**KIRKLEES METROPOLITAN COUNCIL
INVESTMENT & REGENERATION SERVICE**

DELEGATED DECISION TO DETERMINE PLANNING APPLICATIONS

Reference No:	2024/62/90289/E
Site Address:	28, Chapel Fold, Staincliffe, Batley, WF17 7AY
Description:	Erection of single storey rear extension and front porch
Recommending Officer:	Morgan Braithwaite

OFFICER REPORT

PROPOSED
ROOF PLAN

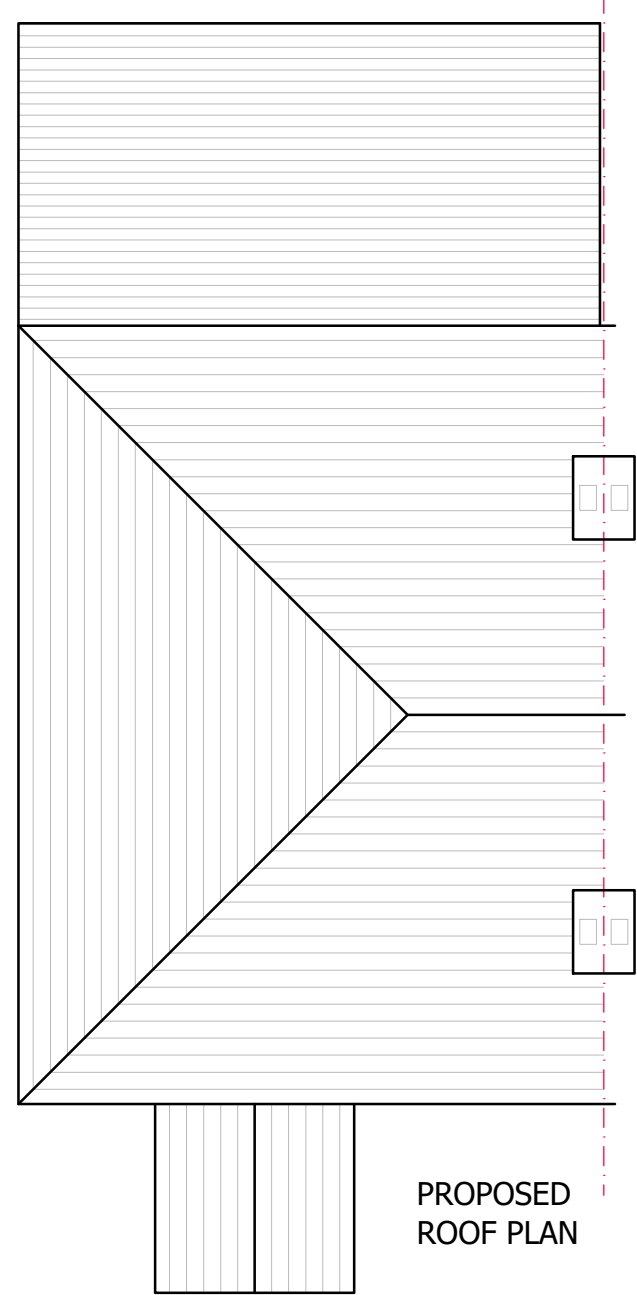
Alterations have been requested through negotiations with the agent handling the application. It was requested that the pitch of the roof would be reduced with the aim to mitigate the potential overshadowing/loss of light or overbearing impact that could potentially be caused by the rear extension. The agent submitted amended plans which have been deemed acceptable.

PROPOSED
REAR ELEVATION

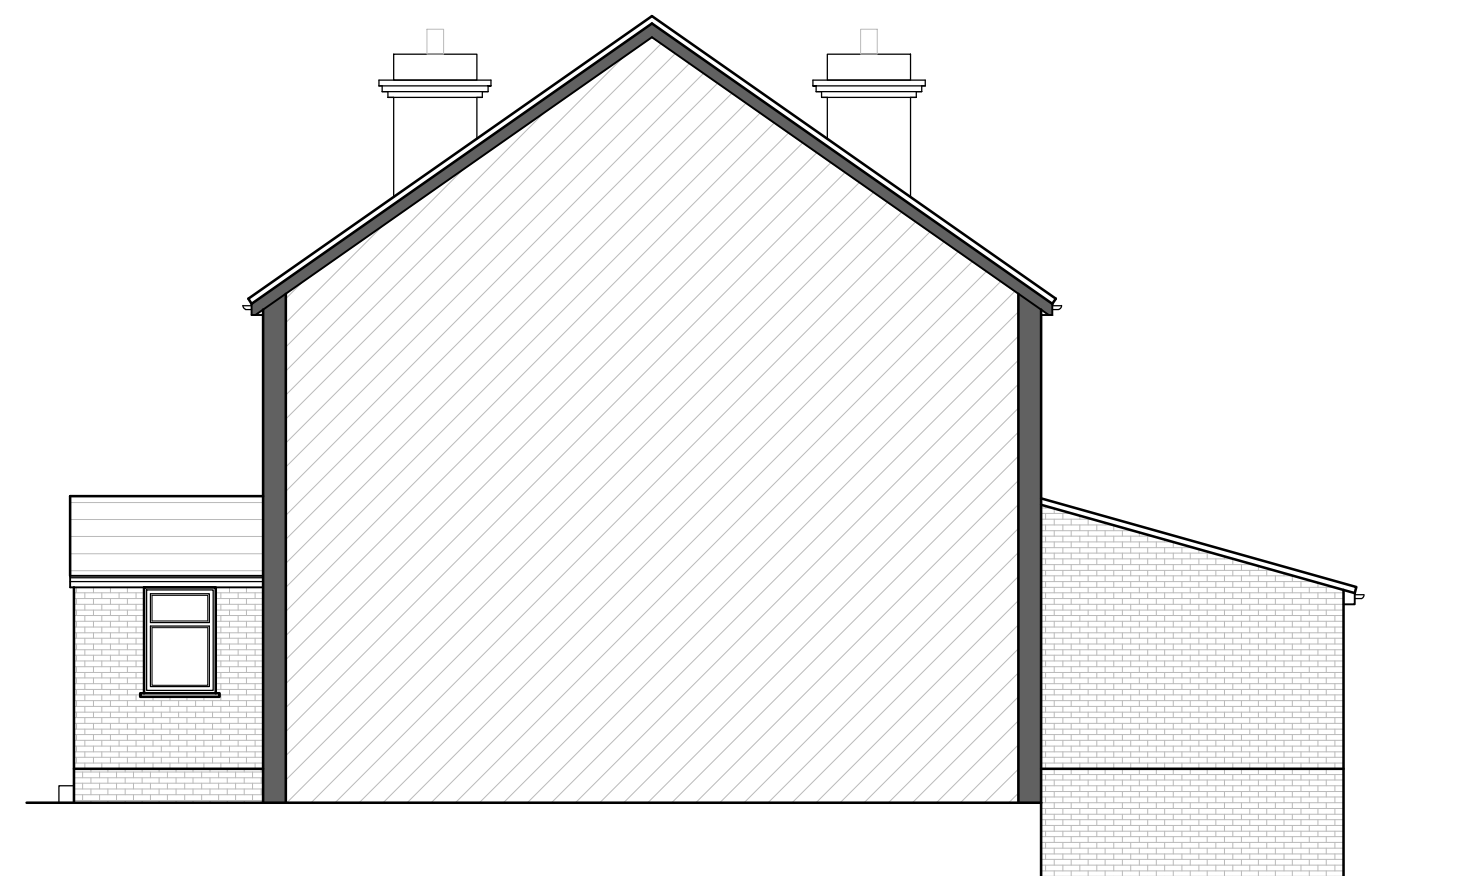
The other element of the proposal shall not be visible from the street scene as it relates to the rear elevation of the existing dwellinghouse. The proposal shall be single storey in scale, however, it does not comply with the House Extensions and Alterations SPD as the proposal exceeds both the projection and height limits stated in the document. As with the porch, the rear extension shall be constructed of materials which match that of the existing dwelling house. This would also have a larger projection than that which would normally be considered acceptable, however the immediate locality is characterised by properties which have undergone substantial extension and addition and the proposals would not have an adverse impact upon visual amenity, in this context.

No.26 is the adjoining dwelling to the application property. The front porch is not anticipated to have an adverse effect on no.26 due to the minimal location and height of the single storey porch. However, as the rear extension does not comply with the SPD, due to being larger in height and projection, there could be some concern with the overlooking, overshadowing/loss of light or the overbearing impact on no.26. An amended plan was received during the course of the application which showed a reduction in the overall height of the extension. As the proposal would be located to the north east of No.26, it is not anticipated that significant overshadowing would occur.

larger rear extensions being part of the character of the area. The agent has also amended plans to reduce the height of the roof to mitigate any impact on the neighbouring property. As such, it is considered that the development would constitute sustainable development and is therefore recommended for approval.
